**From:** [Haley Mercer](#)  
**To:** [Kelly Bacon \(CD\)](#)  
**Subject:** RE: LP-22-00005 Suncadia Phase 2 Division 8 - Notice of Application  
**Date:** Tuesday, October 25, 2022 11:34:22 AM

**Subject:** LP-22-00005 Suncadia Phase 2 Division 8 - Notice of Application

CDS is requesting comment on the following Long Plat application LP-22-00005 Suncadia Division 2 Phase 8. Links to the file materials can be found below. The comment period will end Friday, November 4, 2022. CDS will assume your agency does not wish to provide comment if not received by this date. Please let me know if you have any issues accessing the materials.

SHEET:
PP-03
 3 OF 6 SHEETS

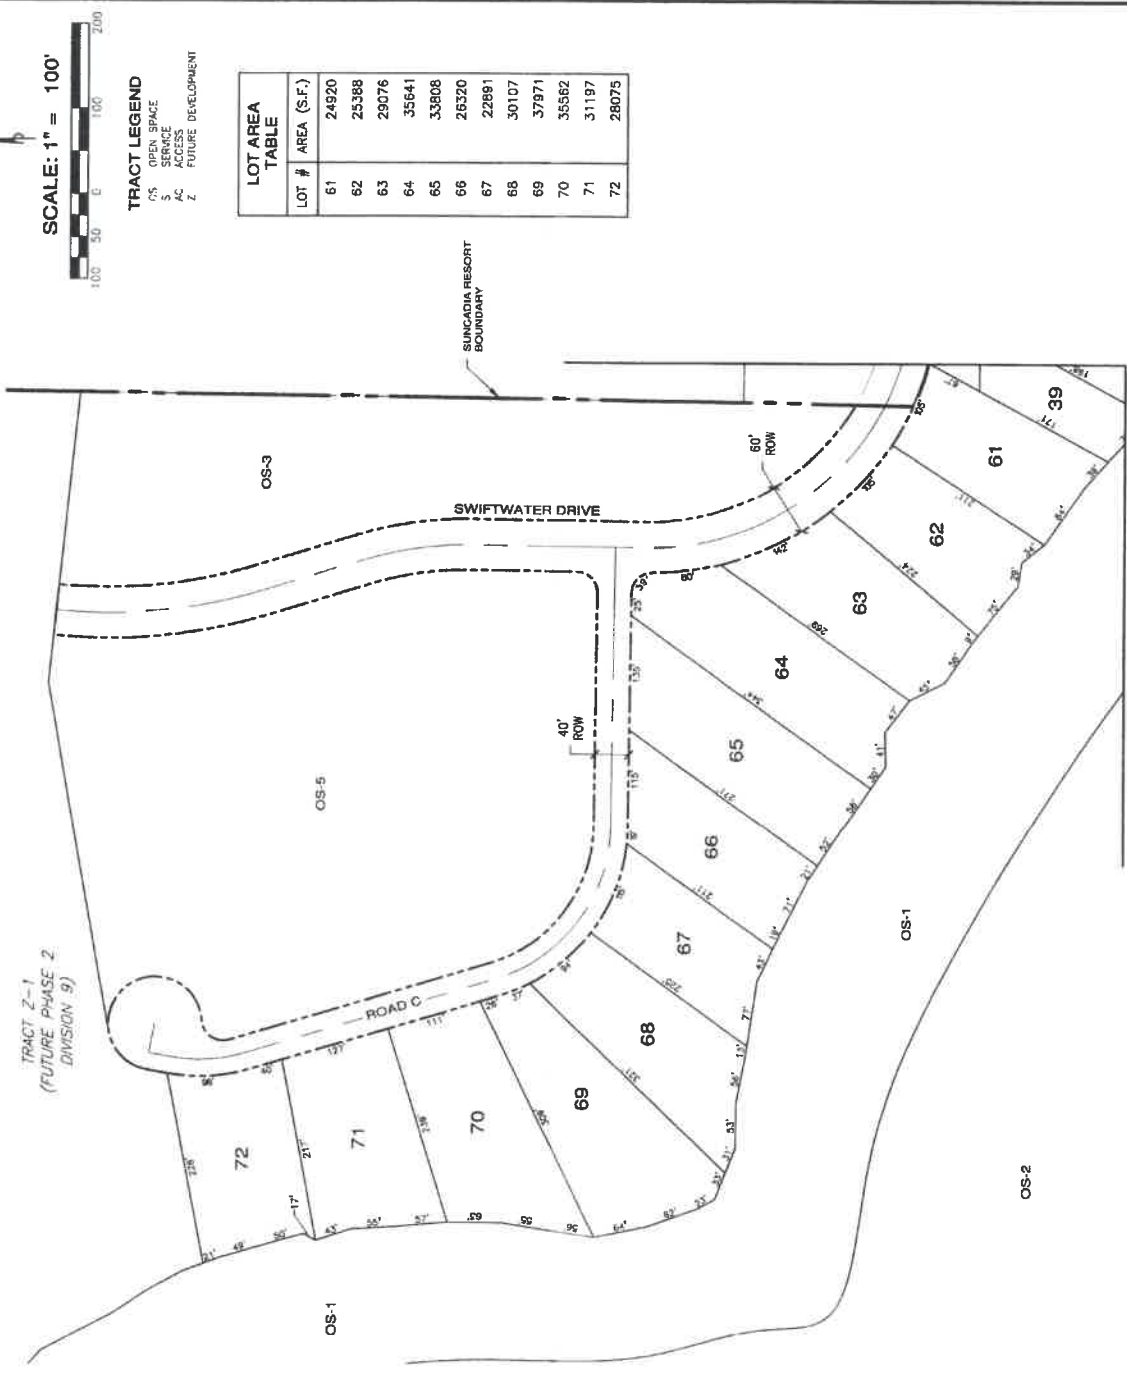
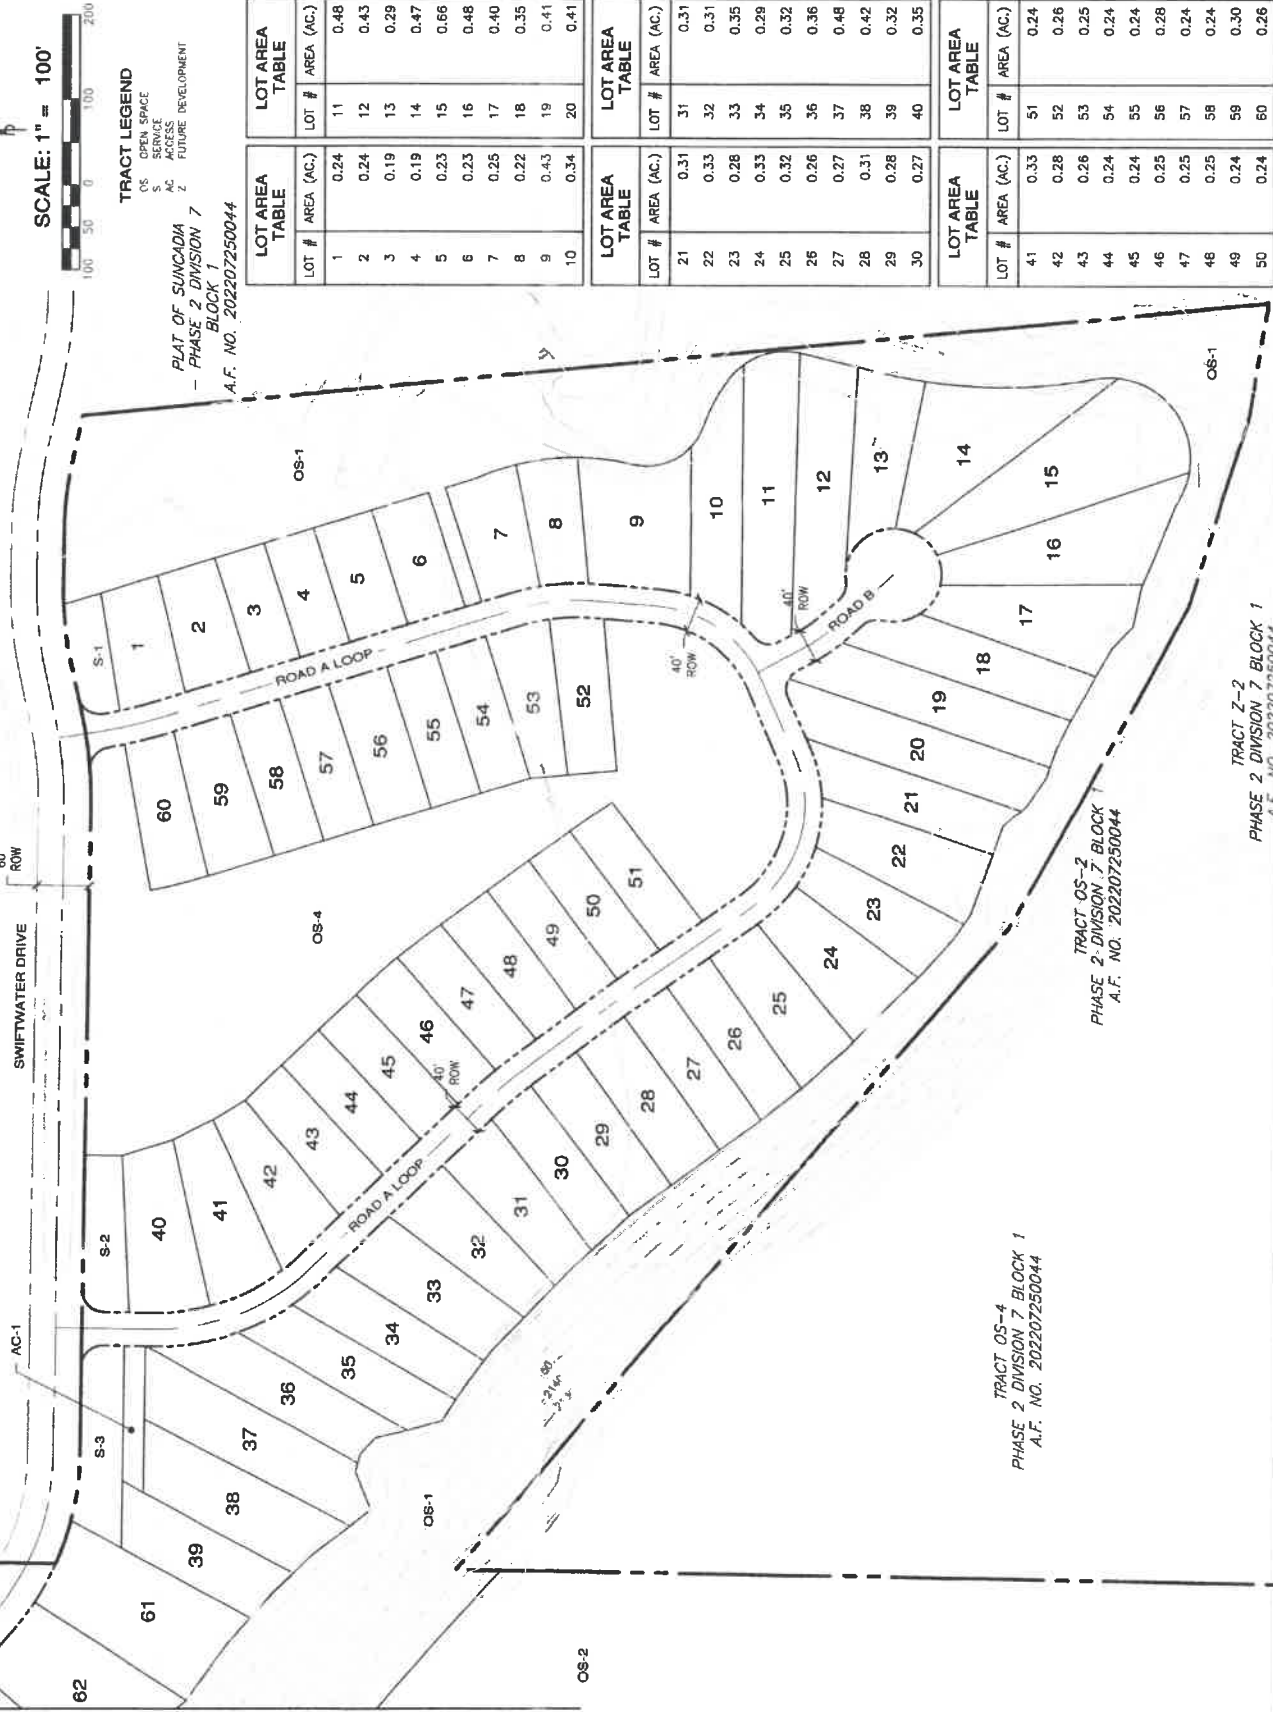
After reviewing the Preliminary Plat Sheets provided in the Internal Link, a few things I noticed on the map:

- Section 13 is not referred to at the top of the map with the other Section call outs.
- Where the Tax Parcels are listed: Parcel 962679 (the other MBSW parcel for Tract Z-3 is listed, Parcel 962676) is not referenced.
